From: Simon Davis
Sent: 28 October 2020 10:53
To: 'Simon Robinson' [REDACTED]
Cc: Daniel Vick <Daniel.Vick@arun.gov.uk>
Subject: RE: BR/244/20/PL Beach Hotel

Subject: BR/244/20/PL Beach Hotel

Document Title:
Existing Elevations

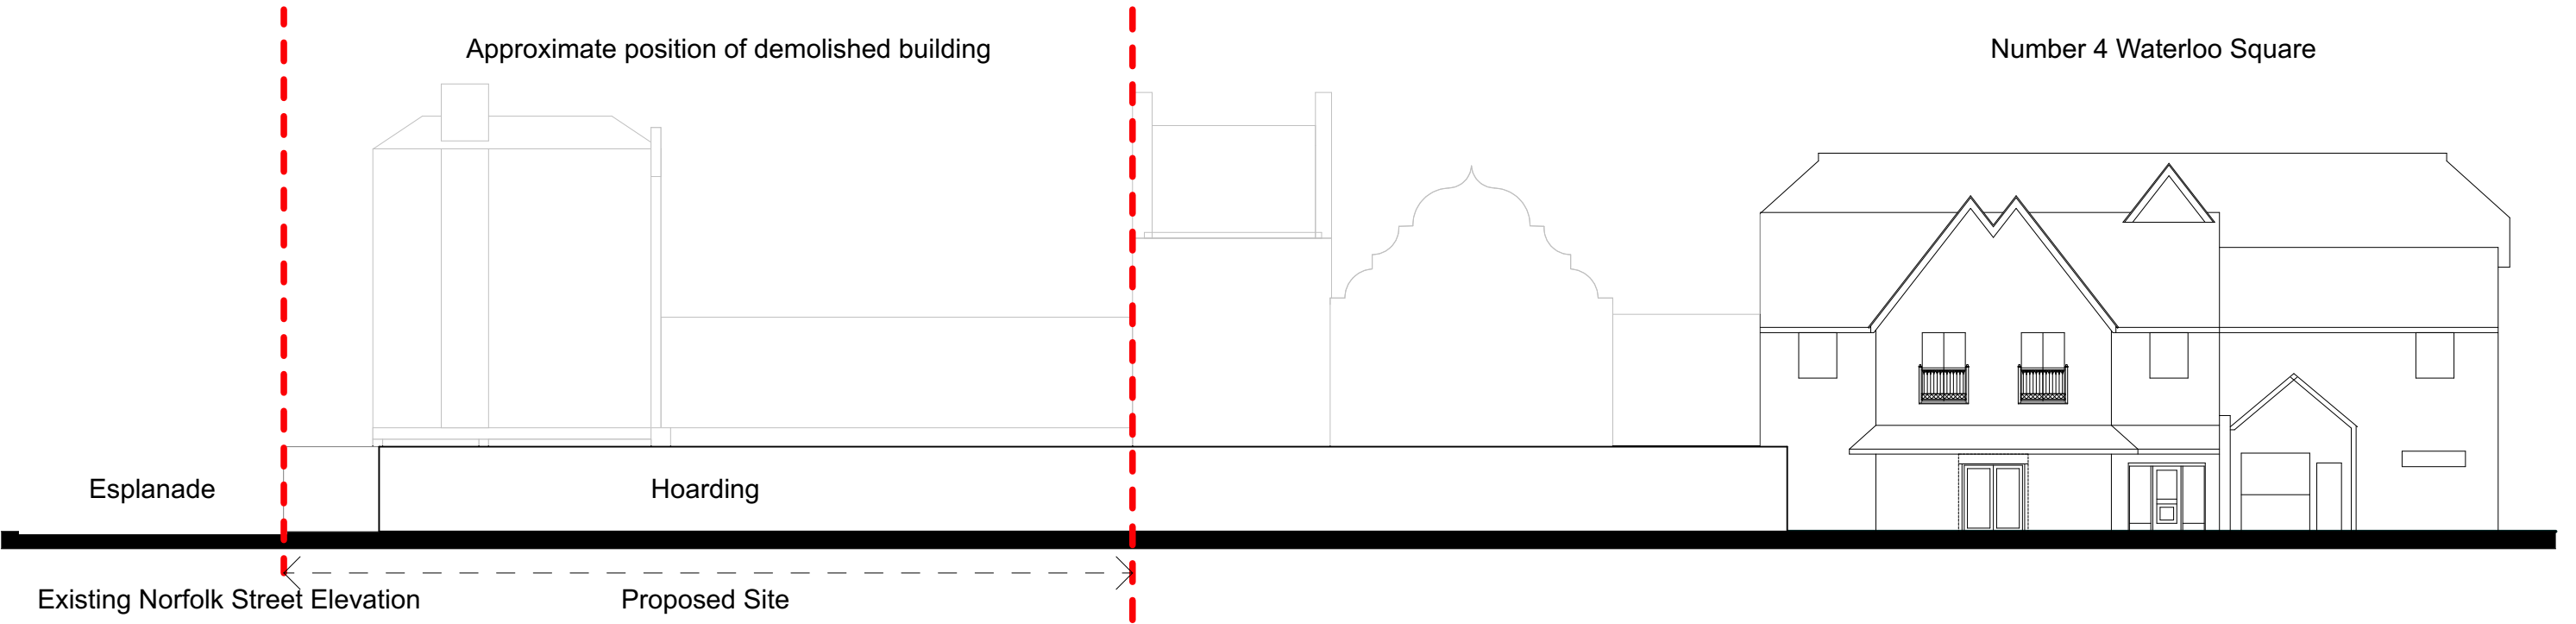
Can you also provide separate plans (elevations) which overlays what was there previously against the proposed.
